BARANGAROO SOUTH

RTS RESPONSE – BAR418–SB-98-03

SEPTEMBER 2017

Comment From Planning And Environment

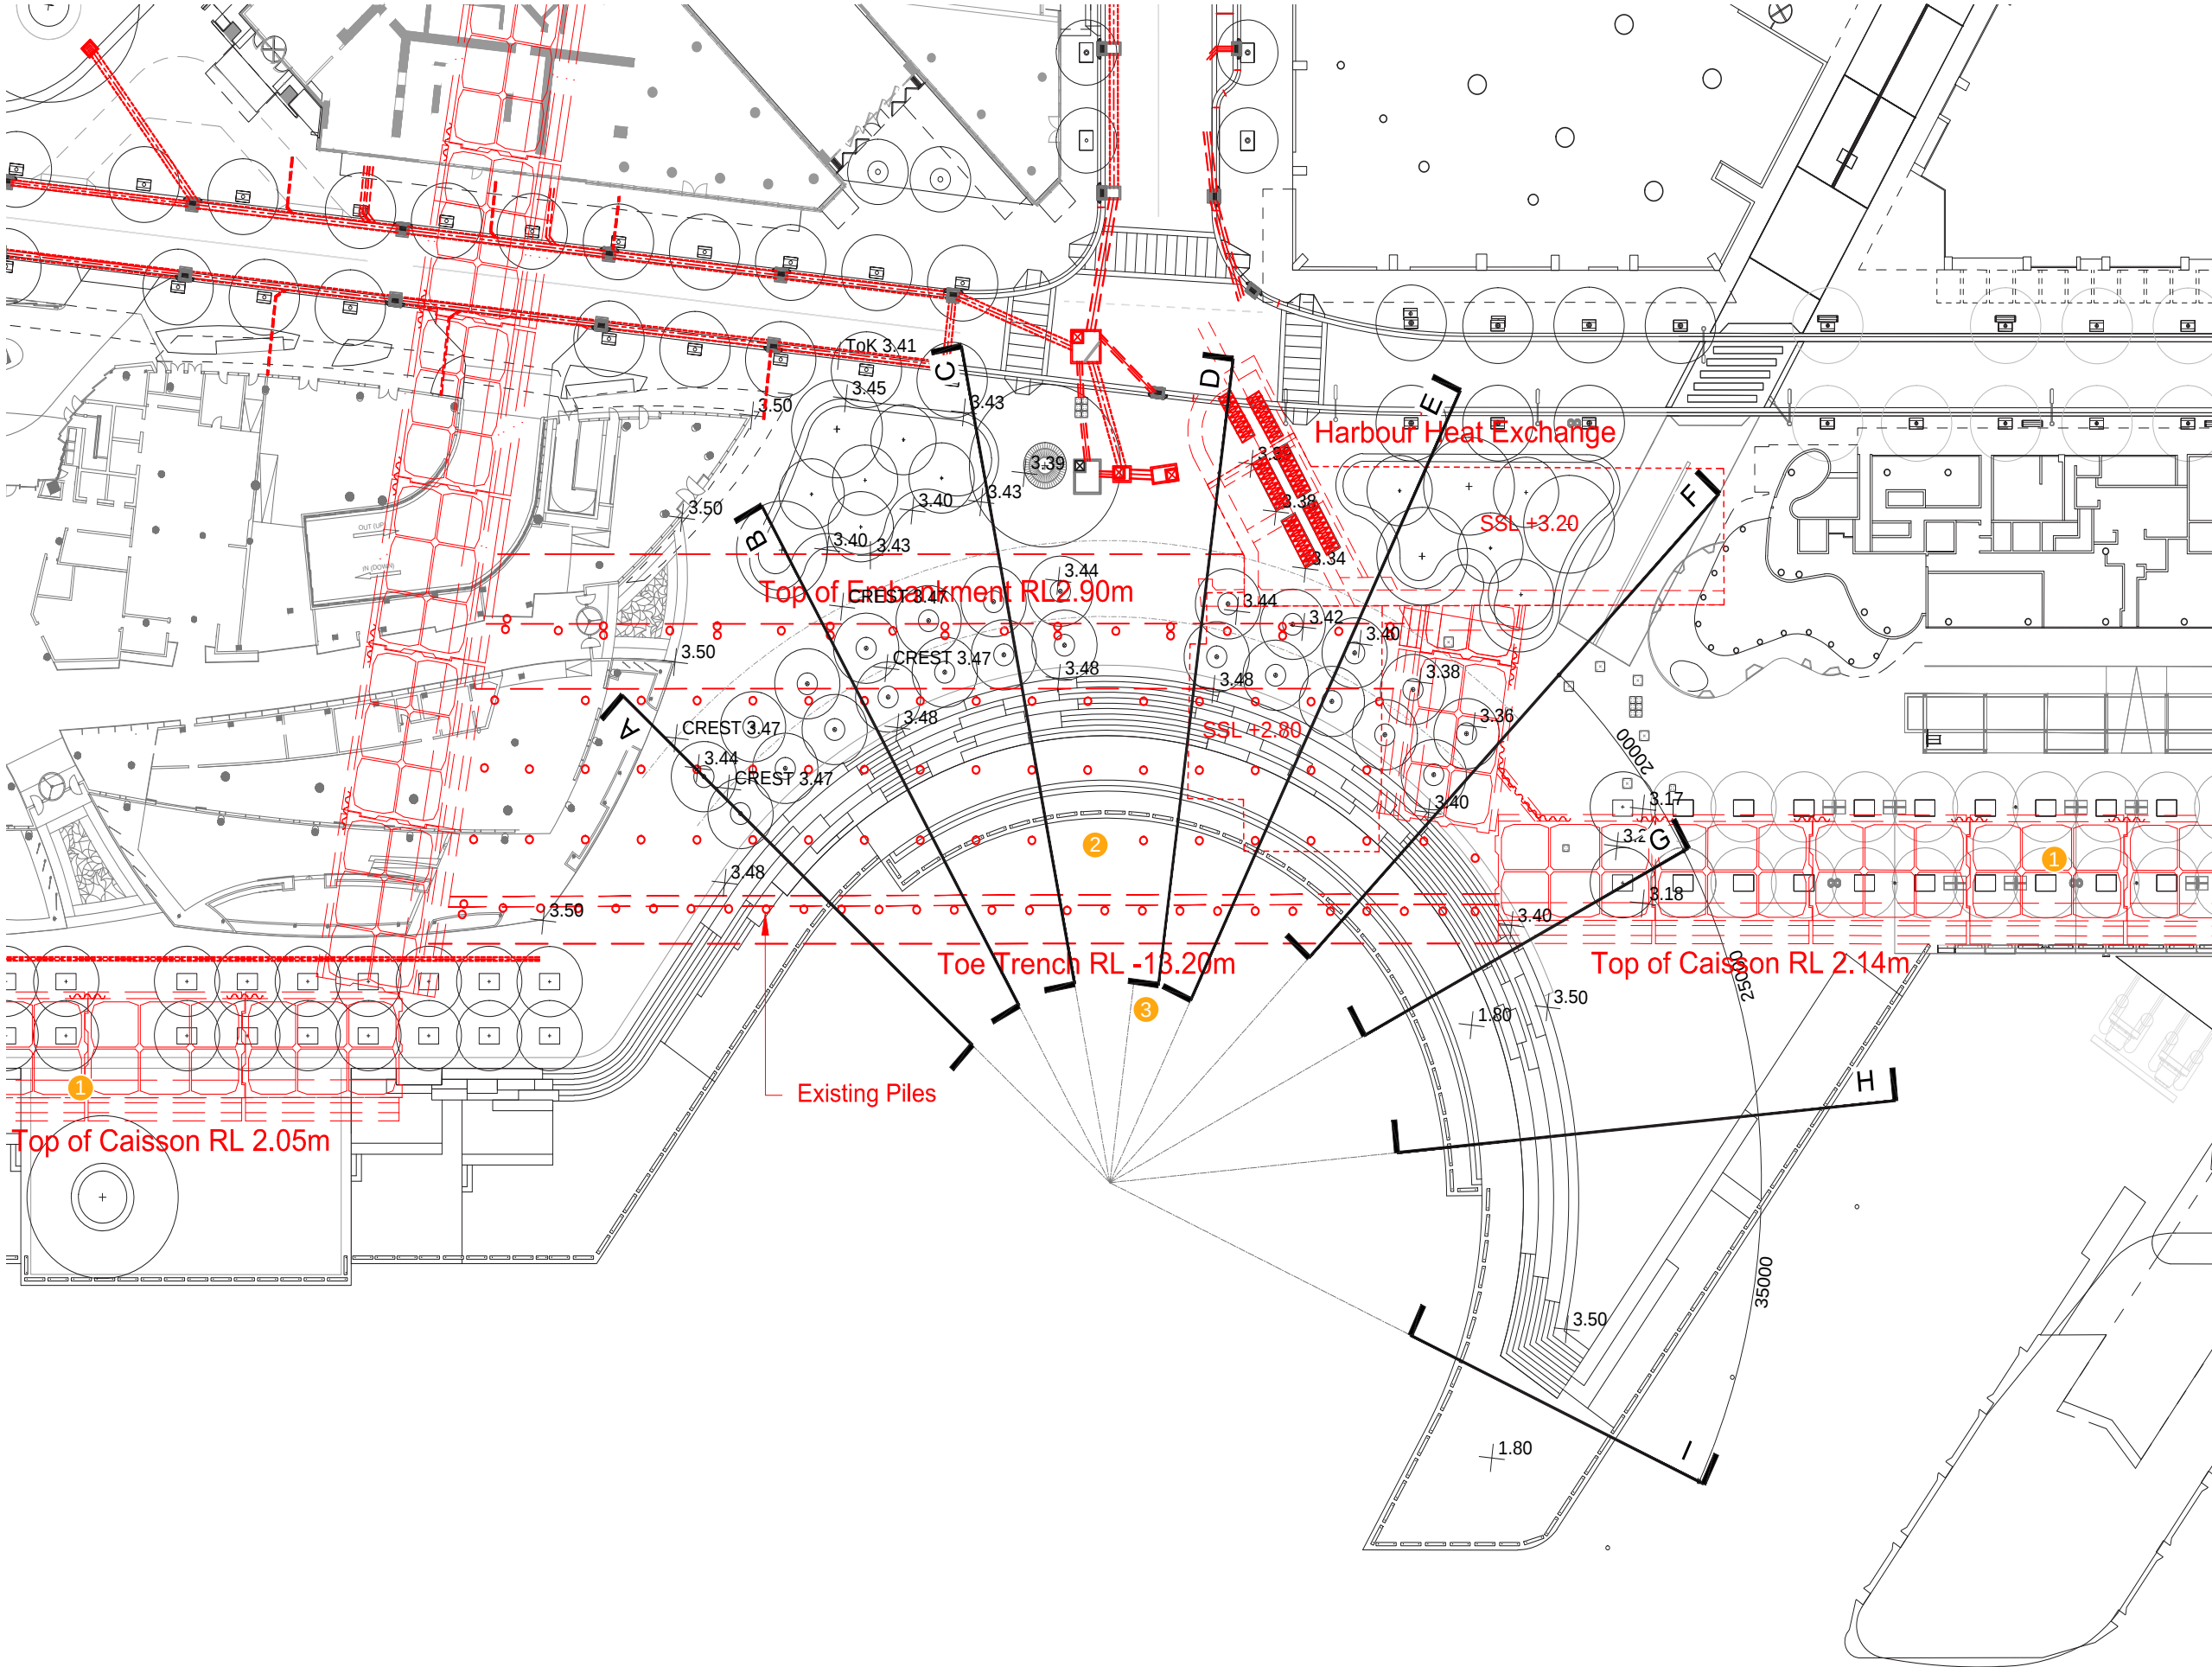
As a resident in the Anadara building I am looking forward to the continued development of the Barangaroo precinct, however, I wish to lodge an objection to a section of the planting strategy in Watermans Cove due to view loss.

The living area of my home provides distant, unobstructed views to the north east, an aspect which is recognised in Part 3 of the Barangaroo south development application report 2017 (design concept) as a “significant” and “key” view. When mature, the proposed avenue planting (Waterhousea floribunda var. ‘Green Avenue’) and raised planter trees (Corymbia maculata and Corymbia gummifera) will heavily filter, if not completely block these views due to the height of the proposed trees and density of their foliage.

I ask that alternate species be selected for the Watermans Cove area that are not overly large and which, at maturity, will not impact the previously unencumbered views to the north east enjoyed by myself and other surrounding residents.

A view analysis has been developed from the information provided in the RTS
Trees species have been modelled at their assumed maximum height given the conditions.
